**Job No: 190372**

**RE: RESPONSE TO SUBMISSIONS TO SSD-10468**

## Inner West Council

PROPOSED CULVERT RELOCATION	
DATE:	AUGUST 2020
SCALE:	1:500 @A1
Project No.	190372
DRG.No.	C20
REV-A

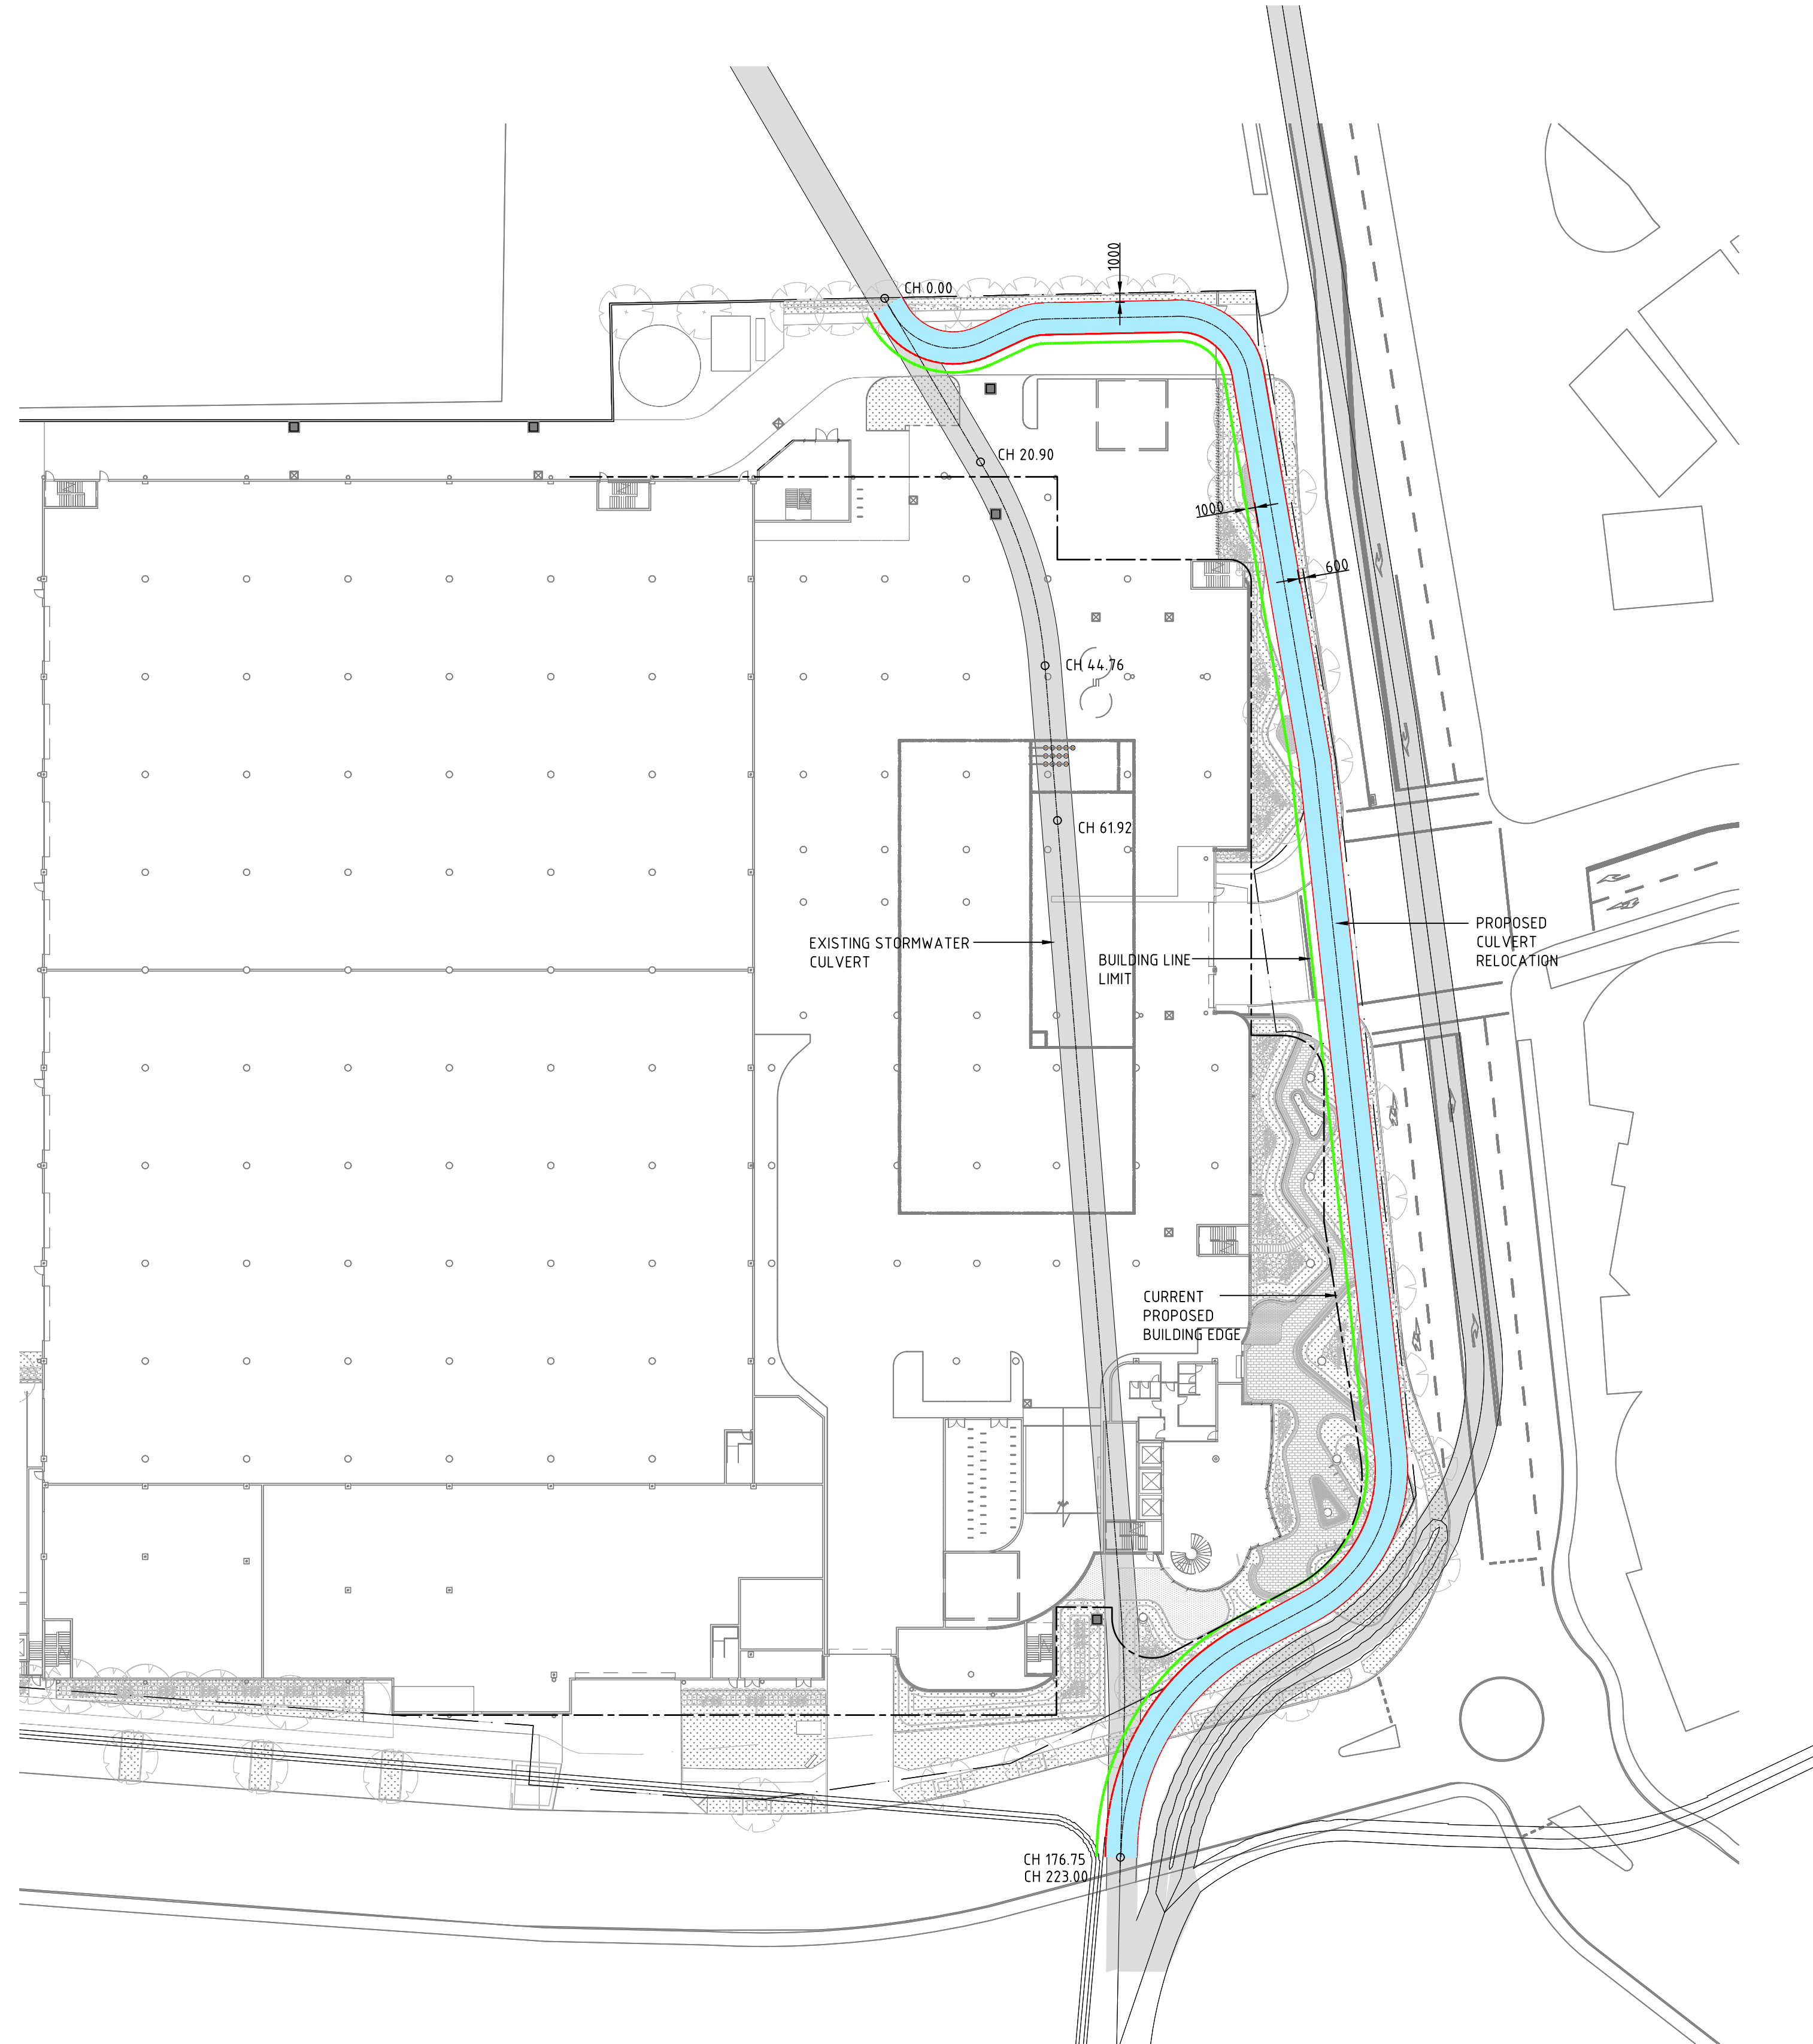
<p><b>Stormwater</b></p> <p>A Council Stormwater pipe drains through the site to the existing Sydney Water Channel. This pipe has not been detailed on any of the submitted plans and it appears that it will be built over which is not acceptable and contrary to Councils DCP 2.25 (Control C31). Council's stormwater asset shall not be built out but be suitably relocated away from the proposed building;</p>	<p>Refer updated civil drawings. It is proposed to terminate the council owned stormwater pipe at the location of the realigned culvert and discharge into the culvert.</p>
<p>Similarly, Sydney Water's stormwater infrastructure is also proposed to be built over, contrary to their guidelines. The stormwater plans even detail columns within the location of the stormwater channel. It is recommended that the applicant approach Sydney Water regarding their requirements with regard to the stormwater Channel.</p>	<p>Sydney water requested that the culvert be realigned to the site boundary. Refer updated civil drawing C20 for the realigned culvert location.</p>

Figure 44 Post Development change in PMF flood depth (m)

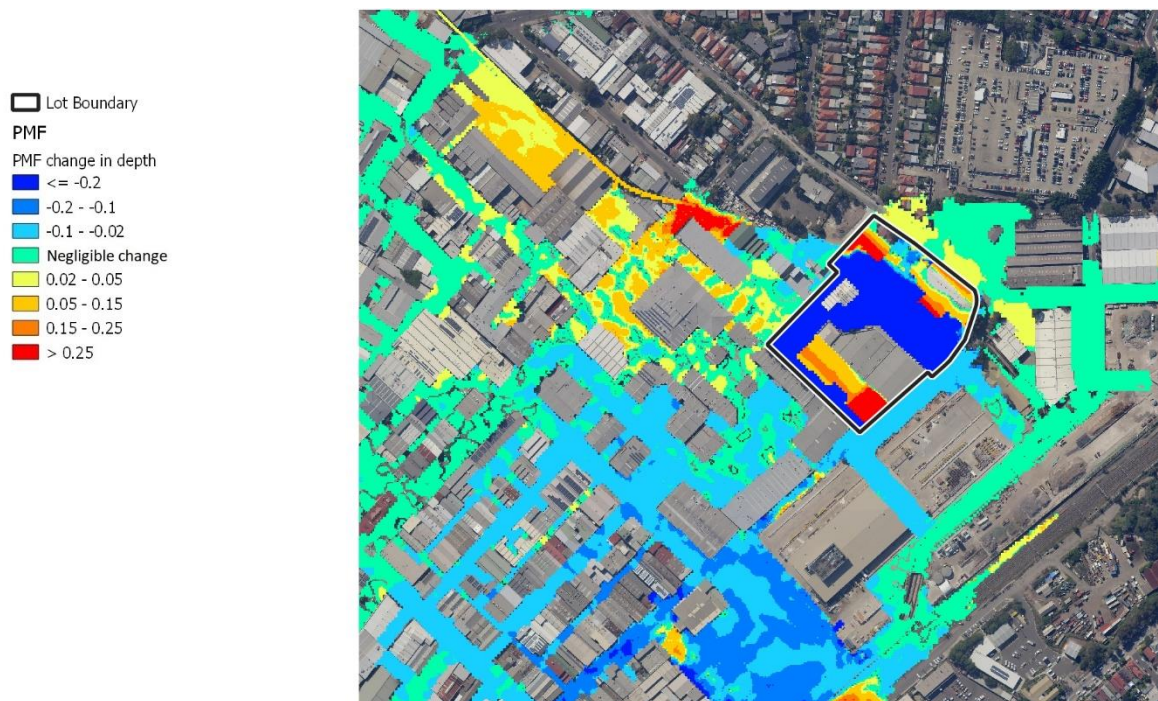
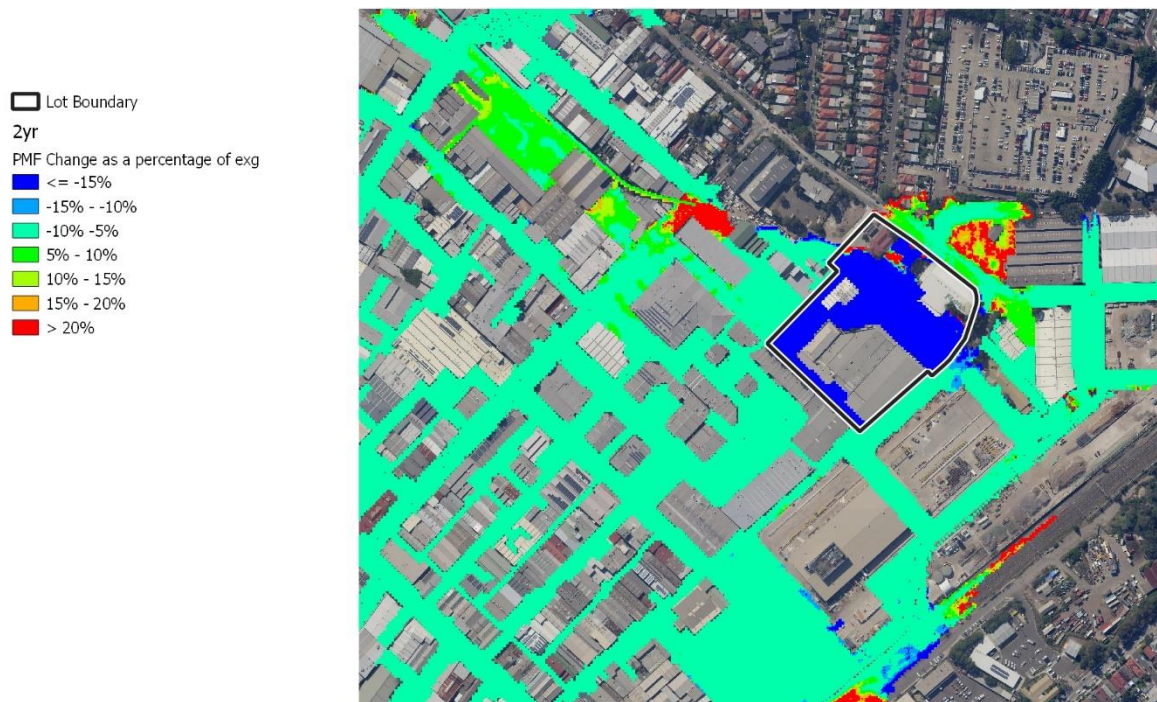
Comment	Response
<p>To better understand the potential consequence of failure, and to better inform the amount of blockage factors to apply, and verify the acceptance of a reduced freeboard (of 300mm) the Flood Management Report should also include a post development flood scenario (change in flood depth map) with total blockage of the inlet structures.</p>	<p>Refer updated flood study for 100% site outlet blockage scenario modelling. Refer Fig 33 and Fig 43 in flood study for blockage scenario results.</p>
<p>A post development PMF change in flood depth map should also be provided as adjacent redevelopment sites (for example Marrickville Metro) have produced Flood Emergency Response Plans based on existing PMF levels and an assessment needs to be made if the change in PMF levels post development is of any consequence.</p>	<p>Refer updated flood study for PMF change in flood levels. Refer Fig 44 and Fig 45 in the flood study for PMF change in flood depths.</p>
